**Consultation Response from KC,  
Highways Development Management**

**2024/92713 adj, Forrest Way, 1 A, Longfield Road, Heckmondwike, WF16 9EJ**

**Erection of detached dwelling**

**Date Responded: 28-1-2025.**

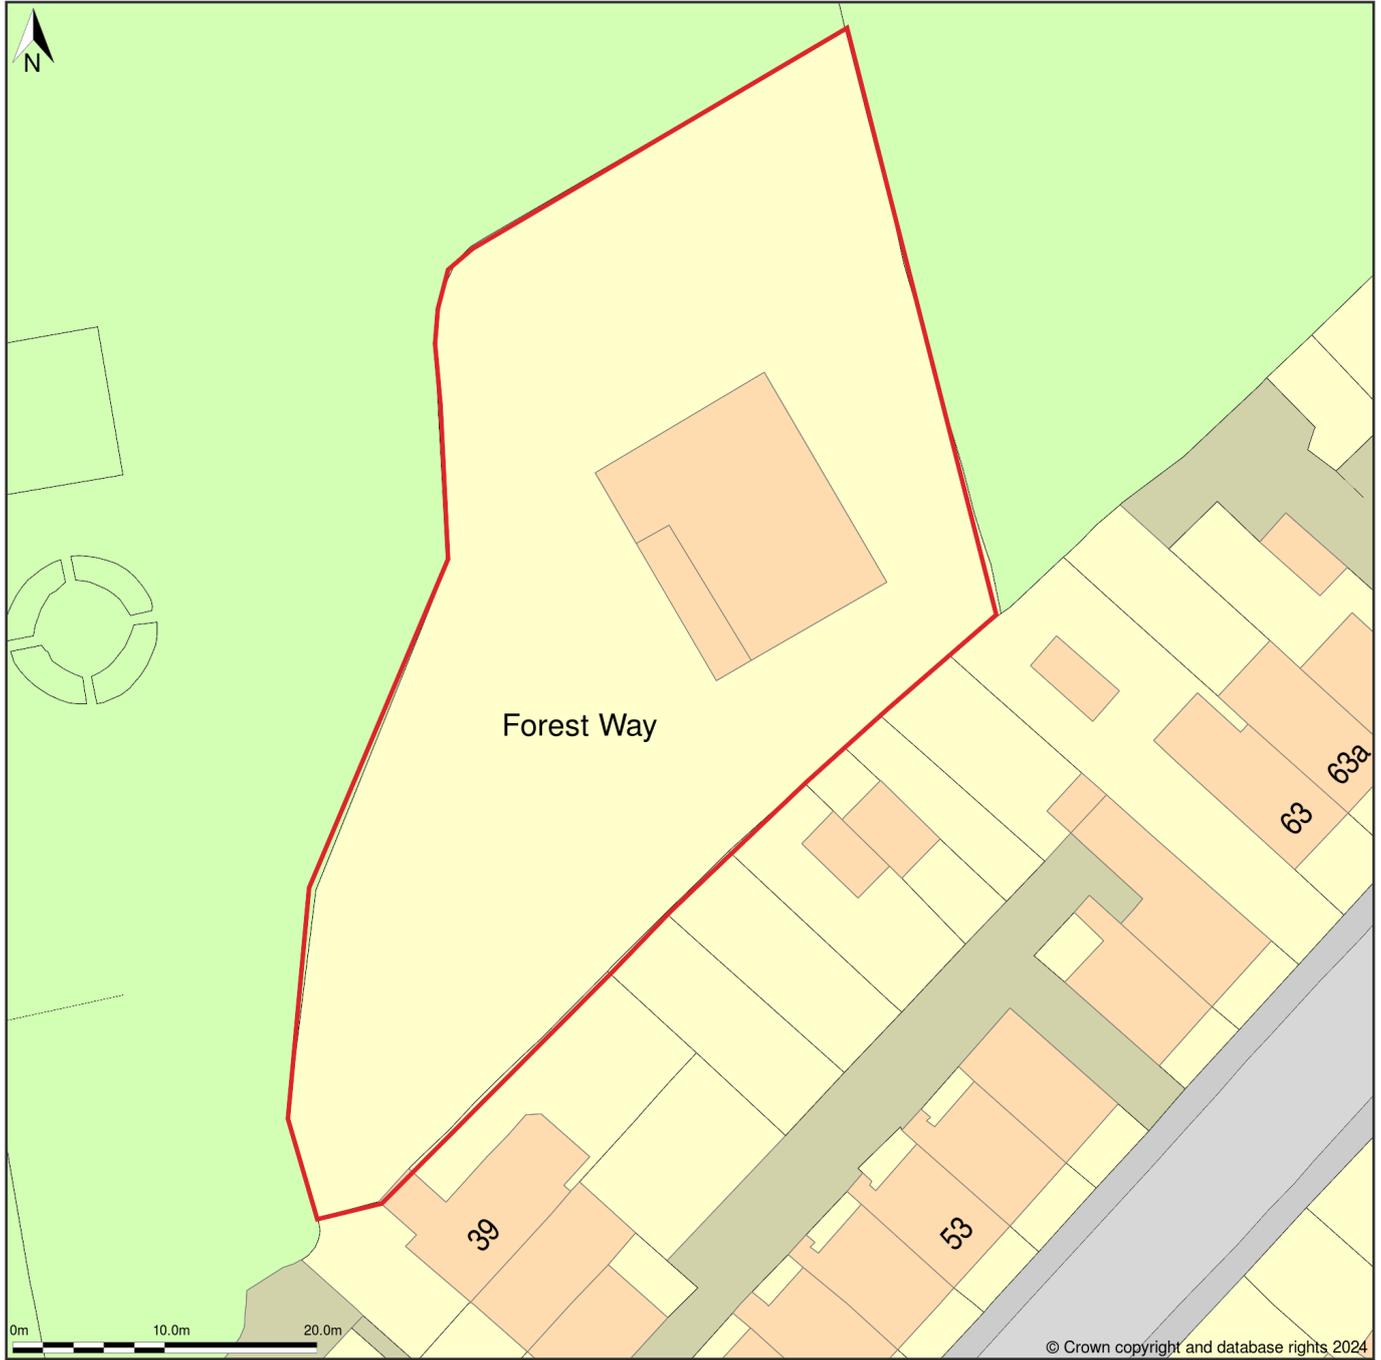
As far as this proposal is concerned the carriageway width is less than 3.7m and turning facilities are not provided.

No improvements are proposed to the section of Cemetery Road leading to the site.

PROPOSED SINGLE PLOTS. ALL ELEVATIONS

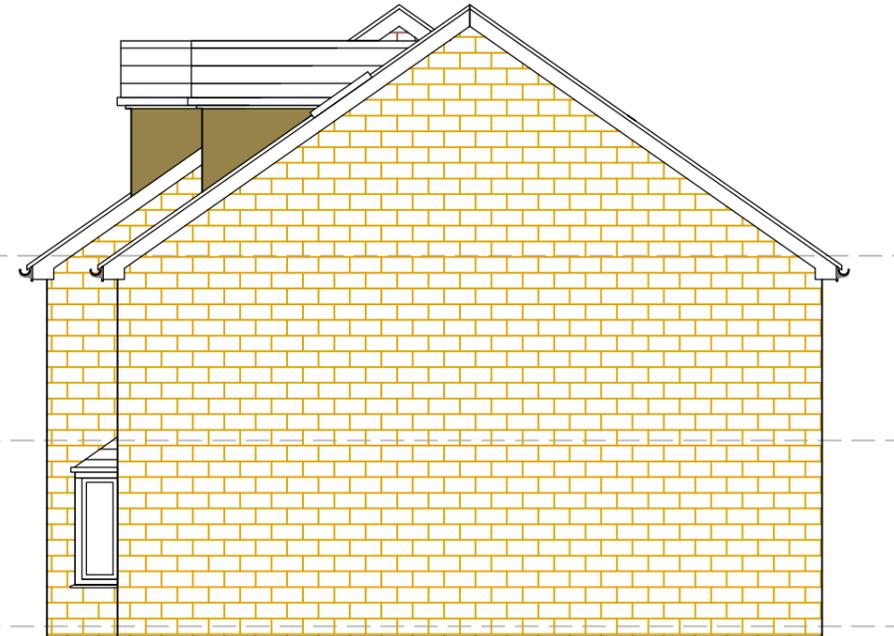
Two off-street parking spaces are shown to the frontage of the proposed dwelling.

Only 2 off-street parking spaces are shown to the frontage of the proposed dwelling. 3 is the recommended standard for a 5 bedroomed house.
